Submission to Western Harbour Tunnel and Warringah Freeway Upgrade EIS 30th March 2020

Objection: Western Harbour Tunnel and Warringah Freeway Upgrade - SSI-8863

Anna Bragg
President P&C
Cammeray Public School P&C

Figure 12-22 Annual mean PM_{2.5} concentration at community receivers

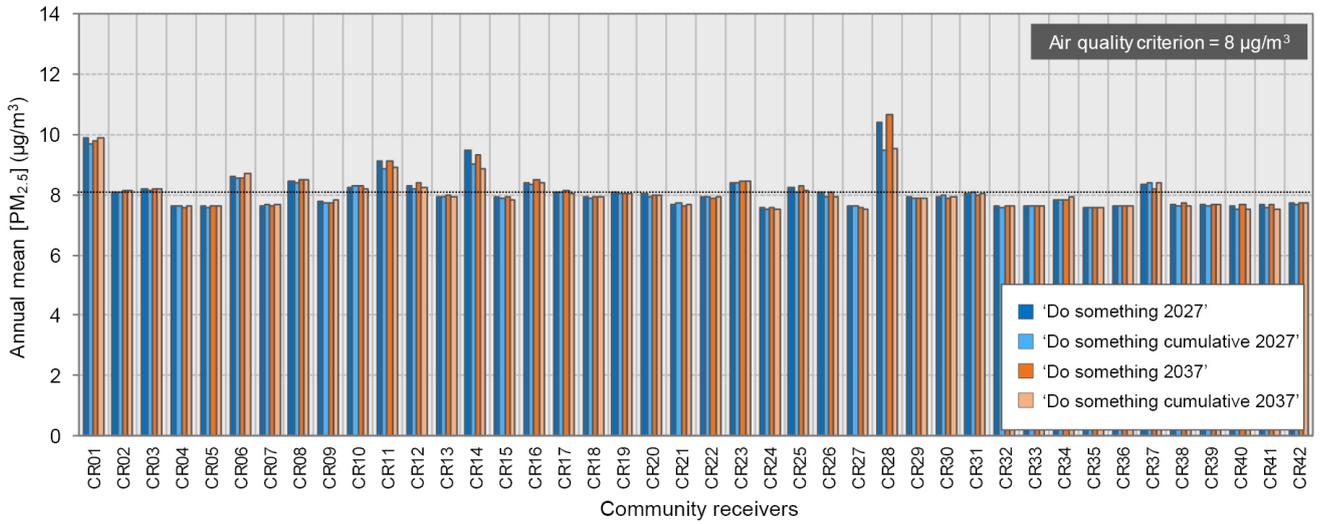
Pollution: (Here [for a summary table of pollution impacts](#)): The ventilation stack servicing the 6.5km stack at Cammeray will not be filtered. The EIS demonstrates concerning impacts in terms of pollution for CPS and its' catchment. All areas will see overall PM2.5 levels well about national criteria when project opens. CPS will experience increases in pollution across NO2, PM10 (annual) and PM2.5 (which WHO states no safe limit). Concerningly our local parks will also be impacted by increased pollution including Green Park, Cammeray Oval, St Leonard's Park and Bicentennial Reserve. Children are most susceptible, particularly at higher respiration rates. The stacks have no emergency ventilation outlets and so fumes from any high pollution events or emergencies will be dispersed over schools in the area. A summary of the CR sites that show an increase in pollution across both projects is attached. Air pollution has been averaged out across a wide span of CR sites which appear unrelated to the Western Harbour Tunnel. As no traffic analysis has been done on Willoughby Rd for example it is hard to claim Roseville is impacted. FOR WHT only relevant sites should be included in the analysis and results should be weighted by number of sensitive receivers. One graph has results covered by the key and the PM2.5 tables do not show the correct criteria level with criterion to be lowered by 2025. [Appendx B](#). Increased rat running due to ramp and accessibility changes will also re-distribute pollution to residential areas increasing the burden on sensitive receivers.

Reissue: the air quality analysis should be completed showing the actual risks to each school in the area (ie CR's should be weighted based on sensitive receiver) taking into account relative elevation and risk, clear information about which houses will have substratum acquisition should be published, reissue visual amenity pictures with clearer artists impressions showing actual buildings.
